MORGAN AND MORECAMBE OFFSHORE WIND FARMS: TRANSMISSION ASSETS

Technical Note: Landscape and Design Matters

Deadline: Deadline 3
7 July 2025

Document reference: S_D3_7

**Figure 1.10: Outline management of PROW within the Onshore Order Limits (Sheet 7)**

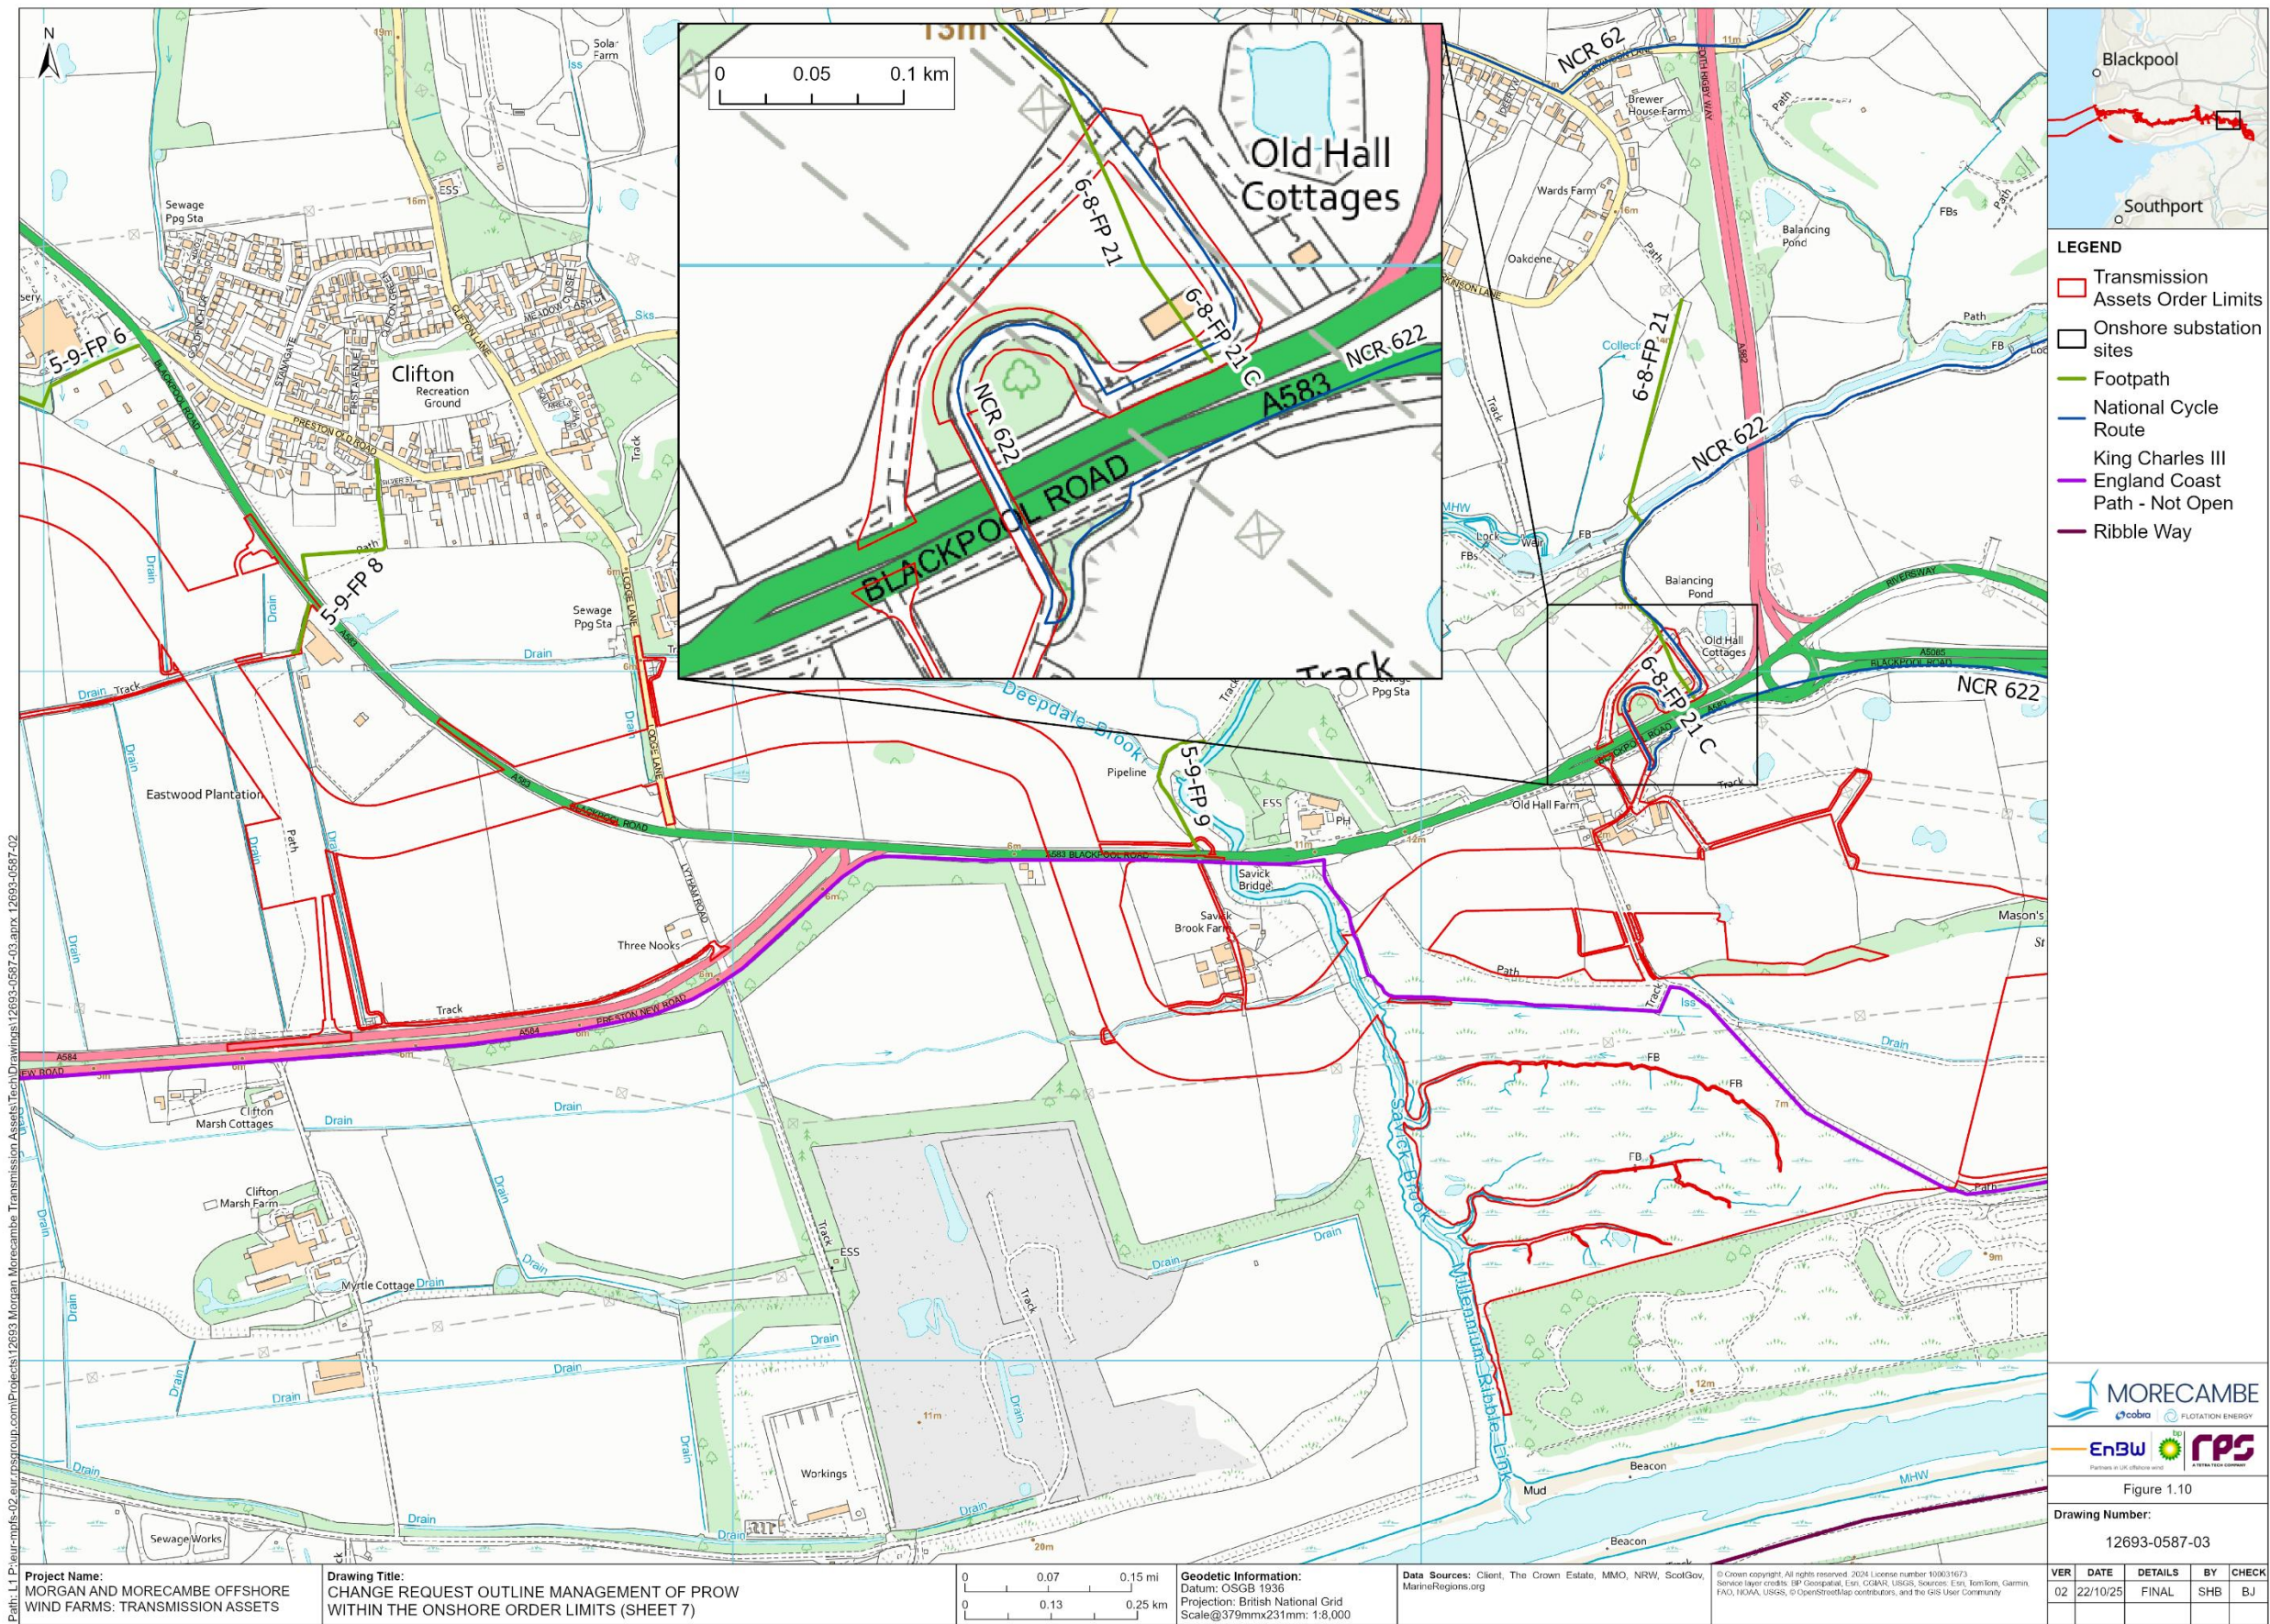
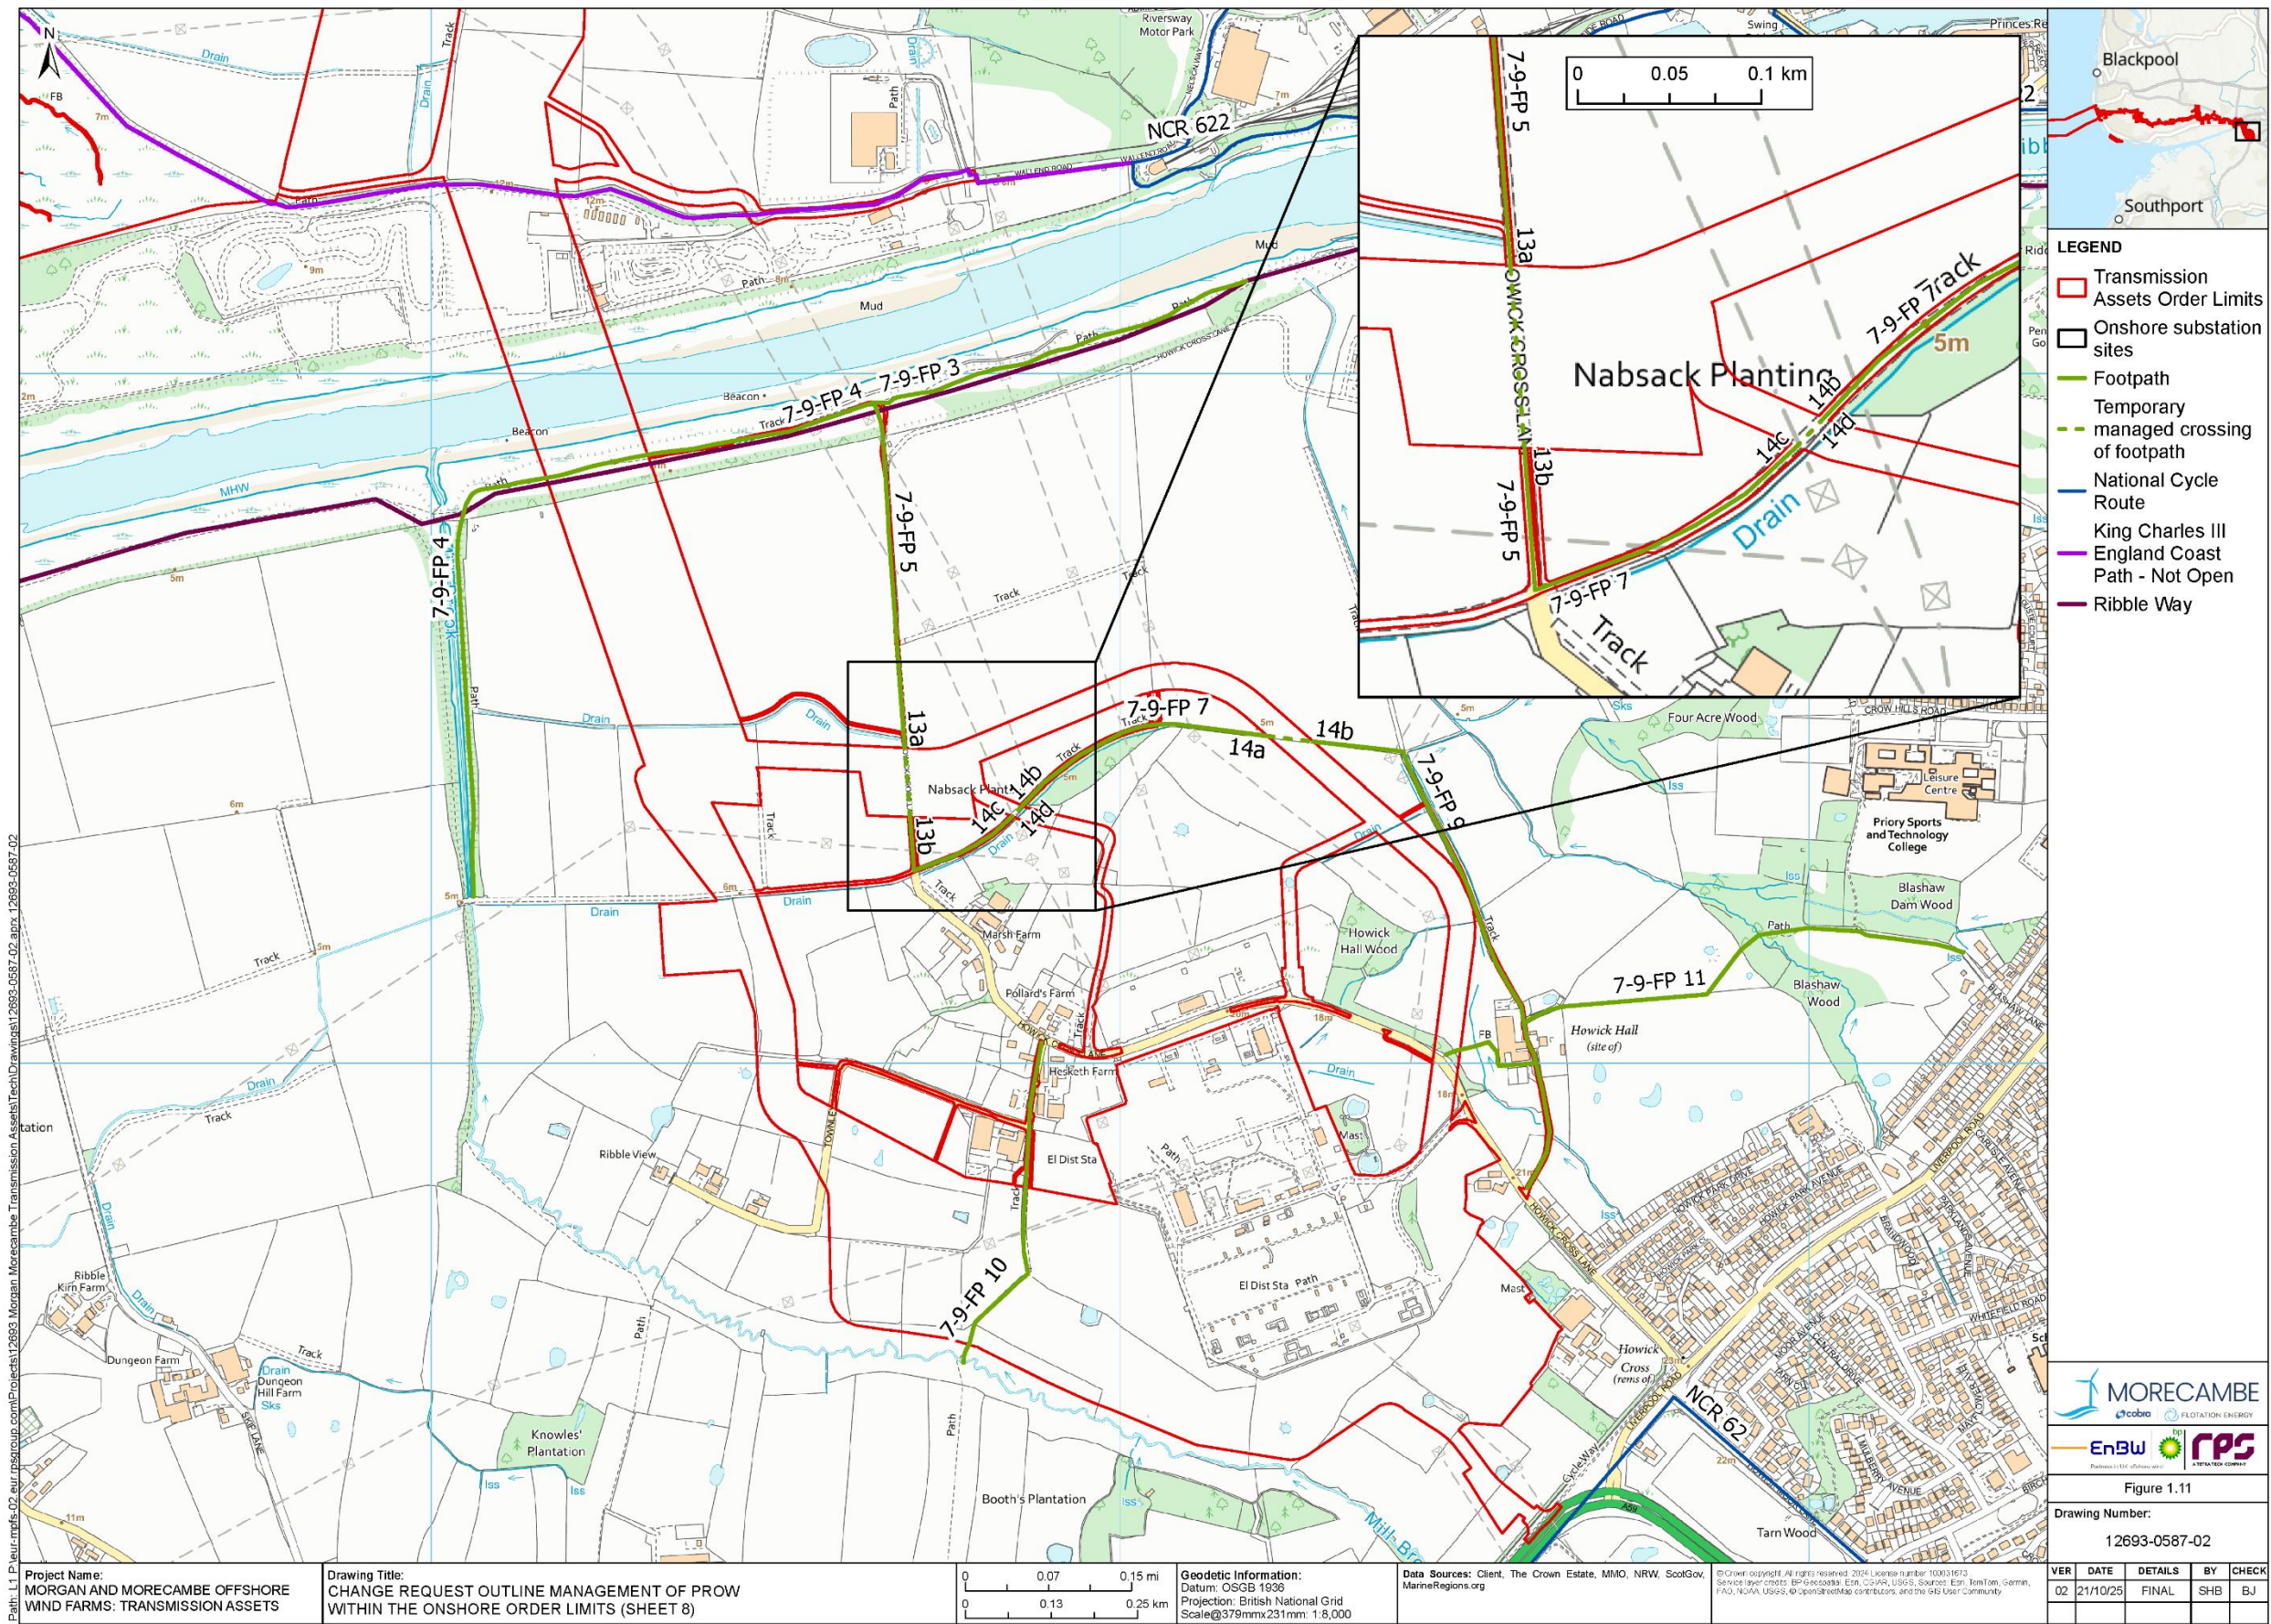
- 1.2.1.1 LCC LIR comment **REP1-085 7.49** raises concerns about the lack of detail in relation to the reinstatement of Public Rights of Way (PRoW) affected by the transmission works, particularly in relation to surfacing materials and demarcation, and requests clarity on how these will be restored, including features such as gates and signage.

- 1.2.1.2 The Applicants refer to the Outline Public Rights of Way Management Plan (AS-048), secured through Requirement 8 of the draft DCO (REP2-004) (dDCO). This Requirement outlines the principles for managing PRoWs during construction, making clear that detailed PRoW Management Plans will be developed and approved by relevant planning authorities, in consultation with stakeholders, before works commence. These plans will include specific information on surfacing and design, as confirmed in Section 1.5.8 of the Outline Public Rights of Way Management Plan (AS-048).
